Address: 25 Woodhead Road Holmfirth HD9 2JU

Application number: 2023/91491	
What is the application for?:	Erection of 61 age-restricted apartments with ancillary accommodation including
Address of the site or building:	Prickleden Mills, Woodhead Road, Holmfirth, HD9 2JU
Postcode:

Type of comment: An objection	
Do you wish your comments to be published on the website anonymously?	No
<p>We are writing to object to restate our objection to the planning application lodged at Prickleden Mills ref:2023/91491 , for which you have received resubmitted drawings and invited reconsultation.</p> <p>These make superficial and cosmetic changes and adaptations to the current live application, and I cannot find any points which address the substantive objections we set out in our letter of objection dated 11/07/23, nor the very significant objections that you have received from the statutory consultees, notably the Environment Agency, Yorkshire Water and Conservation. I trust you will ensure that those objections are addressed in your Officer's report. I will not restate them all again. I have sought to comment further on points highlighted by the architect Acumen's covering letter (5/10/23) acc

Description: **PROPOSED SITE SECTIONS WITH PREVIOUSLY APPROVED OVERLAIN SHEET 2 OF 2**

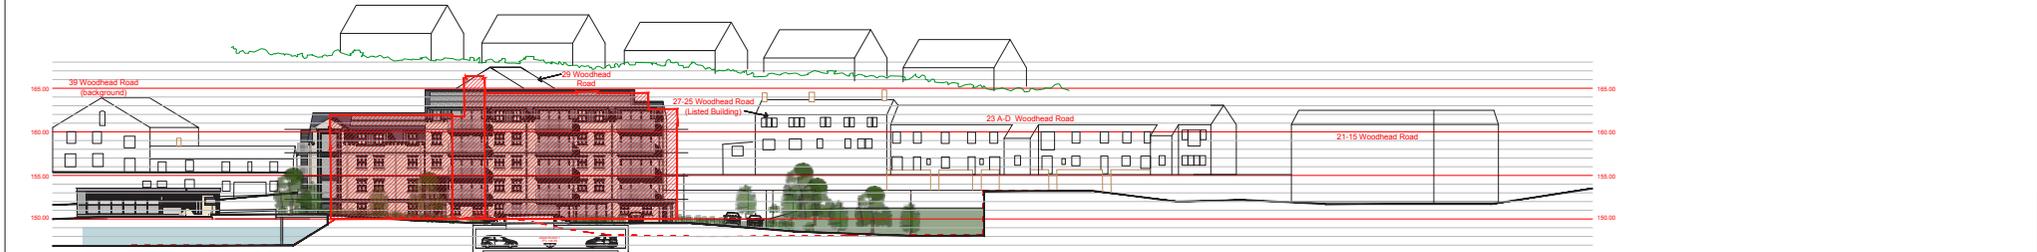
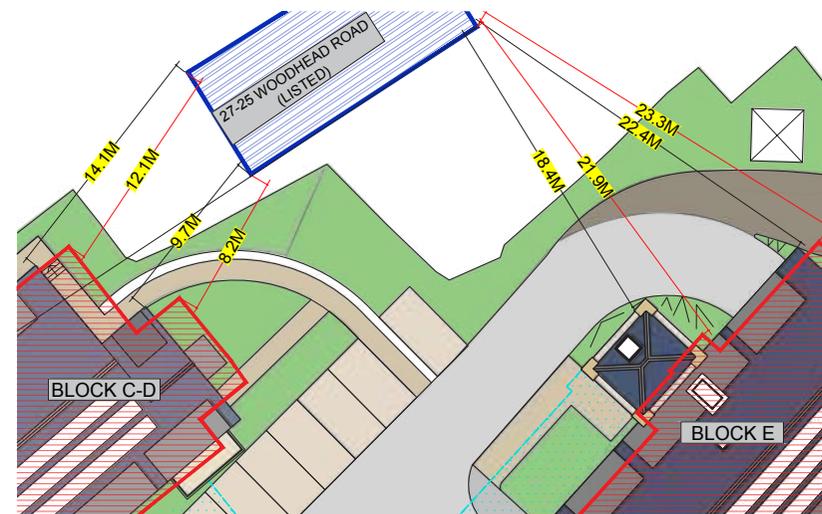
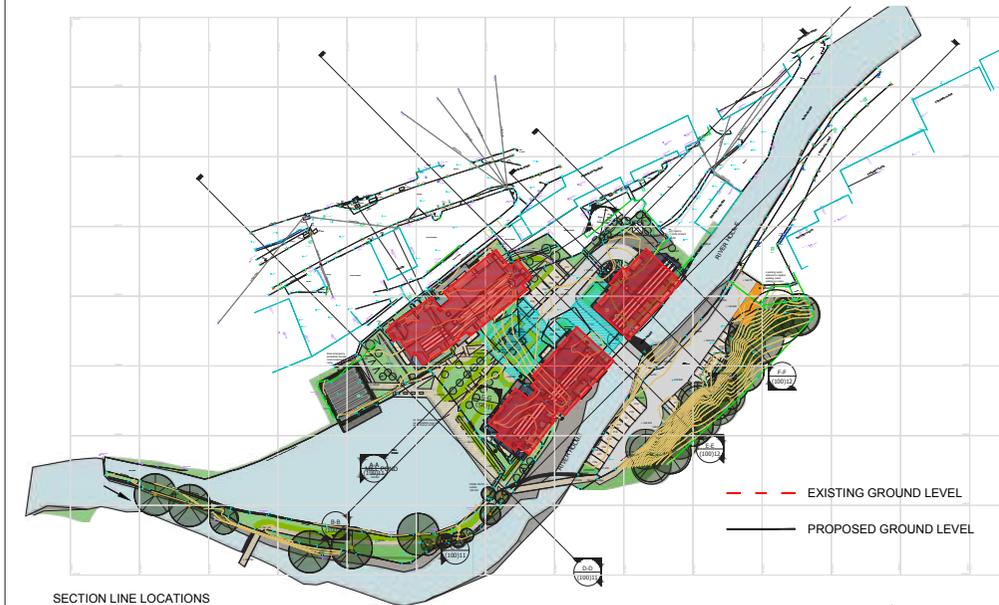
6. Acumen's statement that 'the proposed development is clearly not a dominant feature when seen from Woodhead Road' is also ridiculous. It suggests they have not seen or reviewed Viewpoints 7 and 10 from the Heritage and Visual Impact Statement submitted with their application. They clearly show how the view up the Holme Valley from Woodhead Road for tourist visitors will be obliterated.
